JOB Cabin Mountain Tree Farms LL-08-06

To: Trudie Pettit, Staff Planner
From: Michelle Geiger, Plans Examiner Kittitas County Community Development Services
Date: May 30, 2008
Re: Cabin Mountain Tree Farm Tracts Large Lot, LL-08-06 & Cabin Mountain Tracts Large Lot, LL-08-07

TO: Trudie Pettit, Community Development Services
FROM: Randy Carbary, Planner II *RC*
DATE: May 7, 2008
SUBJECT: Cabin Mountain Tracts Large Lot Subdivision LL-08-00007

TO: Trudie Pettit, Community Development Services
FROM: Randy Carbary, Planner II *RC*
DATE: May 30, 2008
SUBJECT: Cabin Mountain Tree Farm Tracts Large Lot Subdivision LL-08-00006

CABIN MOUNTAIN TREE FARM TRACTS LARGE LOT SUBDIVISION
 A PORTION OF SECTION 8, TOWNSHIP 20N., RANGE 13E., W.M.
 KITTITAS COUNTY, WASHINGTON

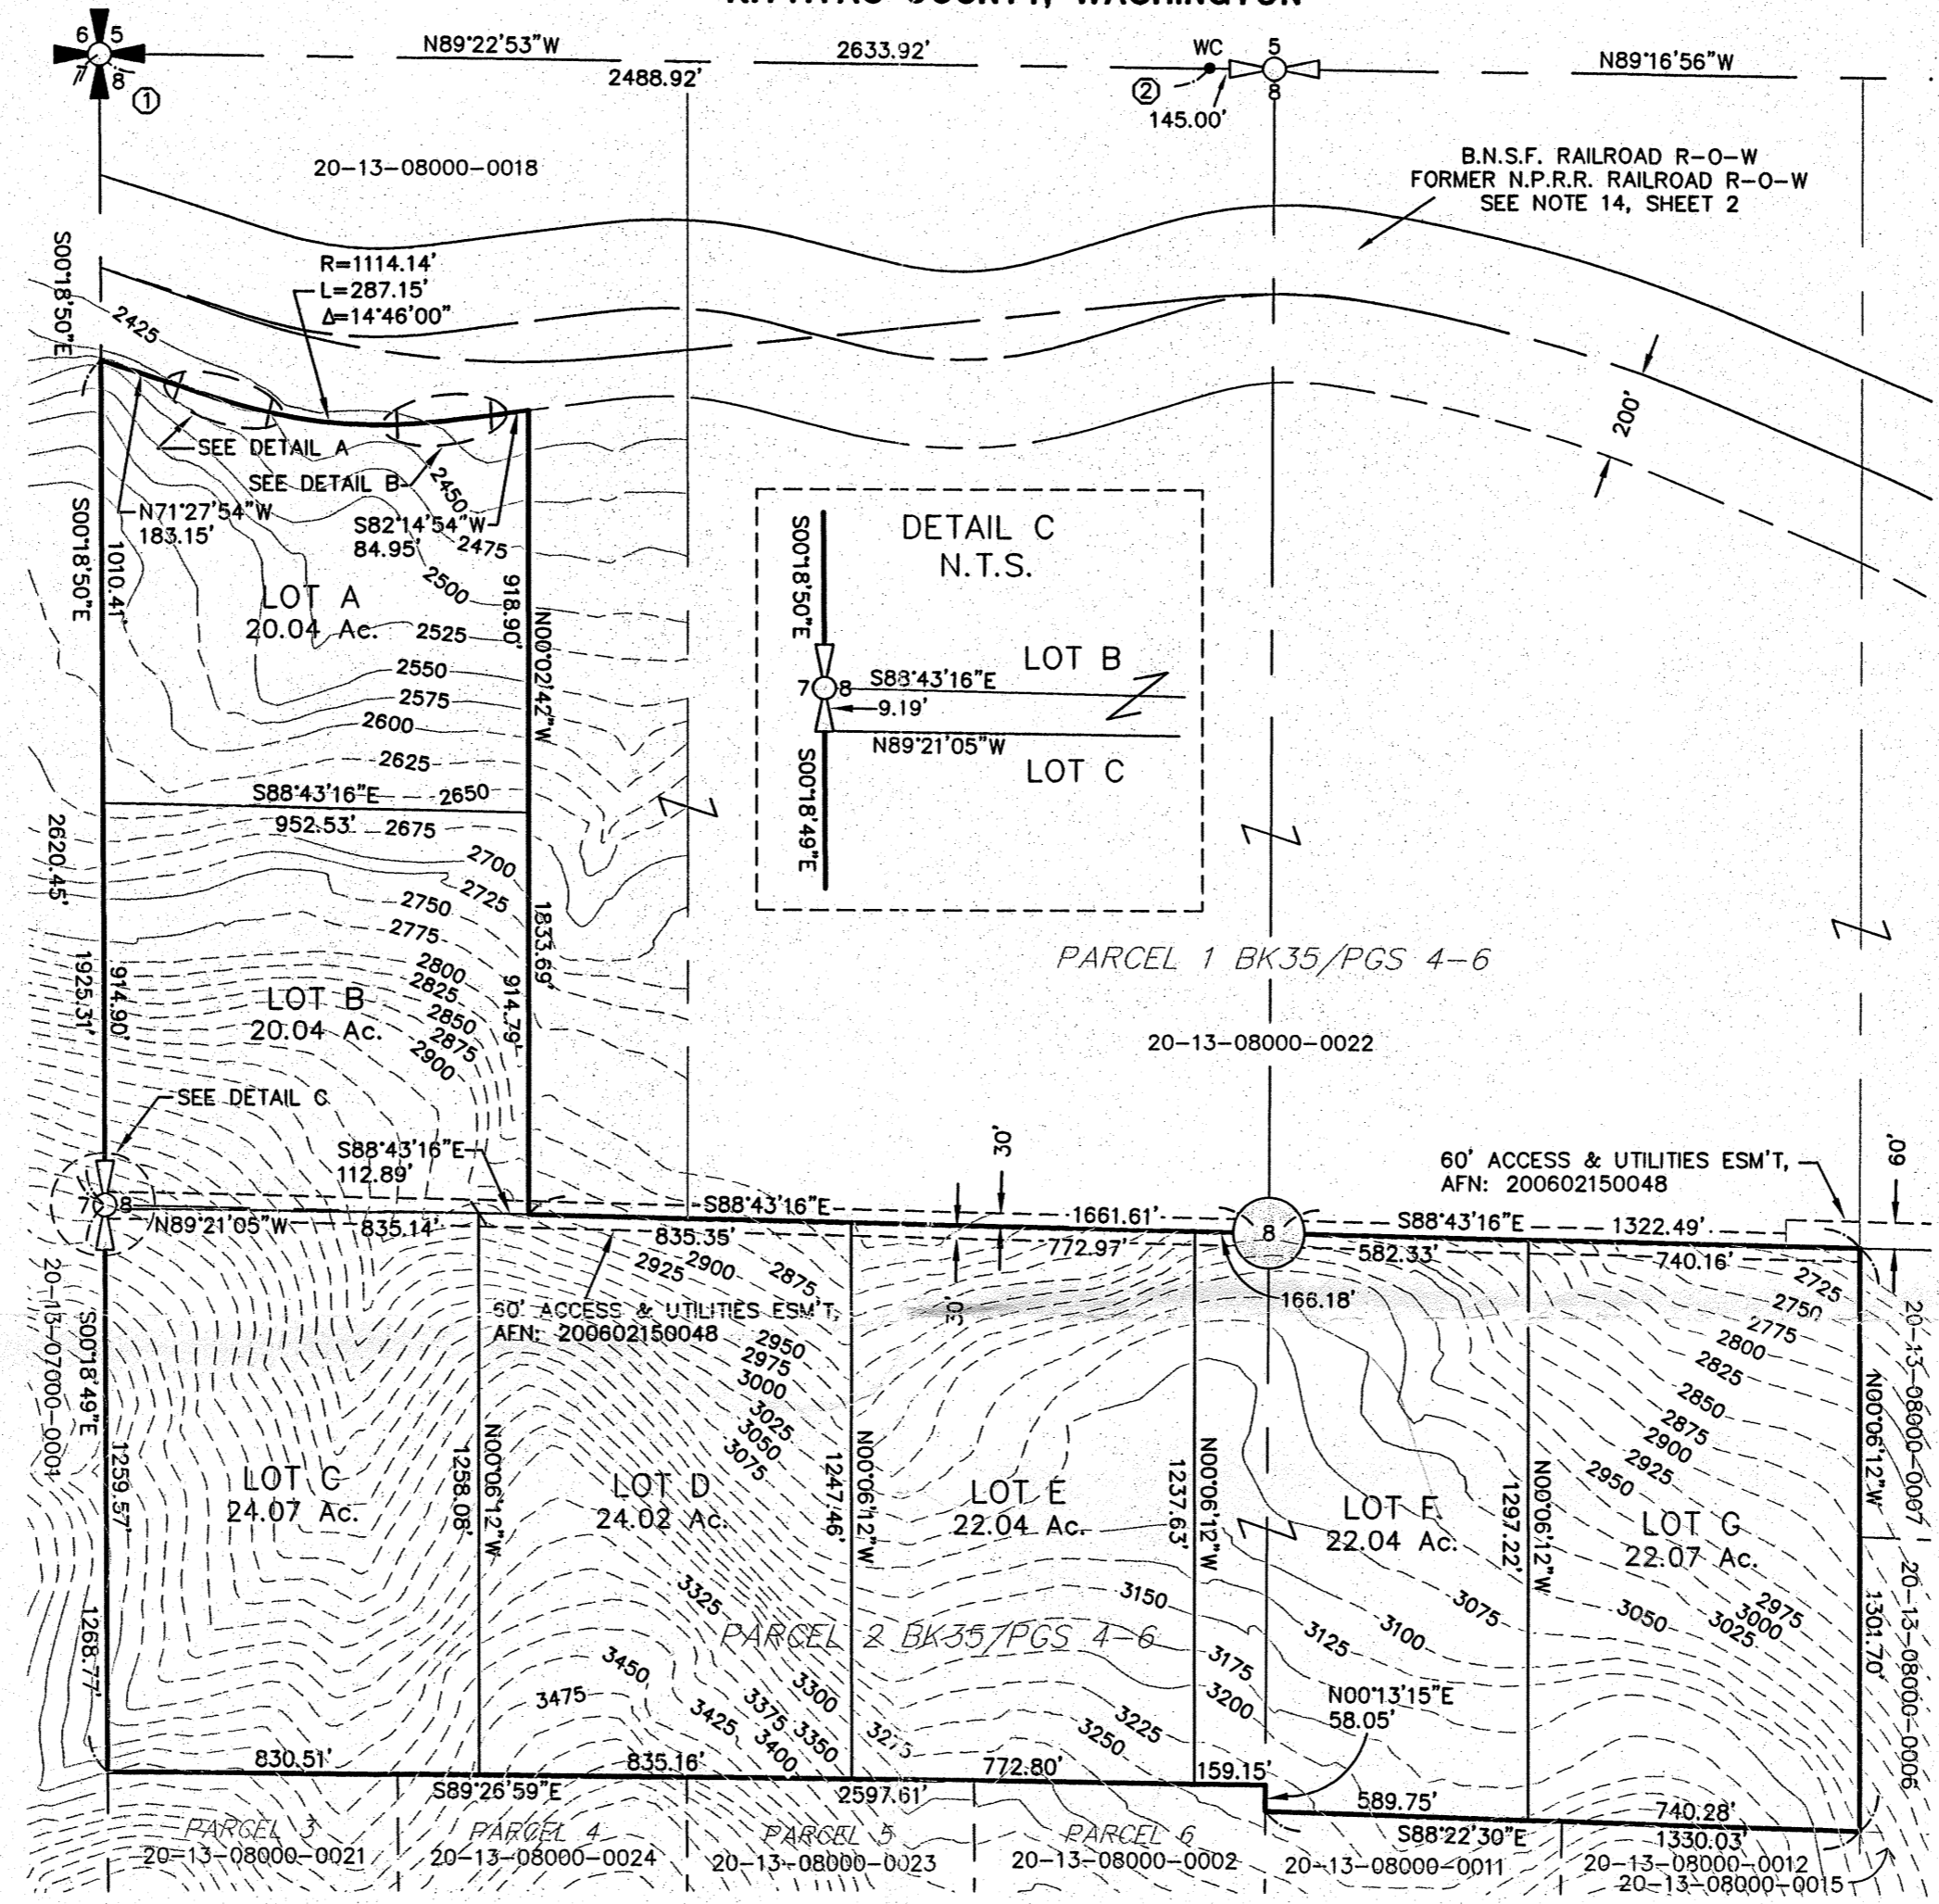
1. Access to Lot A Joint-Use Driveway: Access to lot A is not clearly depicted on the application. Access to lot A shall be via a joint-use access and shall serve no more than two tax parcels. Per Kittitas County Road Standards, 9/6/05 edition.

2. Cul-de-Sac: No cul-de-sac or turn around area is identified on the Large Lot Subdivision application. A cul-de-sac turn-around having an outside right-of-way easement diameter of at least 110 feet shall be constructed at the closed end of all dead-end roads serving 3 or more lots. The driving surface shall be at least 96 feet in diameter. Cul-de-sacs must also conform to the requirements specified by the 2006 International Fire Code. Contact the Fire Marshal regarding any additional cul-de-sac requirements.

The location of the cul-de-sac or turn around area shall be depicted on the face of the Large Lot Subdivision application, prior to final approval of the Large Lot Subdivision., regardless of its location.

4. Private Road Improvements: Access to lots A thru H shall be via the 60' Access and Utility Easement as depicted on the face of the plat. Access shall be constructed as a Low-Density Private Road. See Kittitas County Road Standards, 9/6/05 edition.
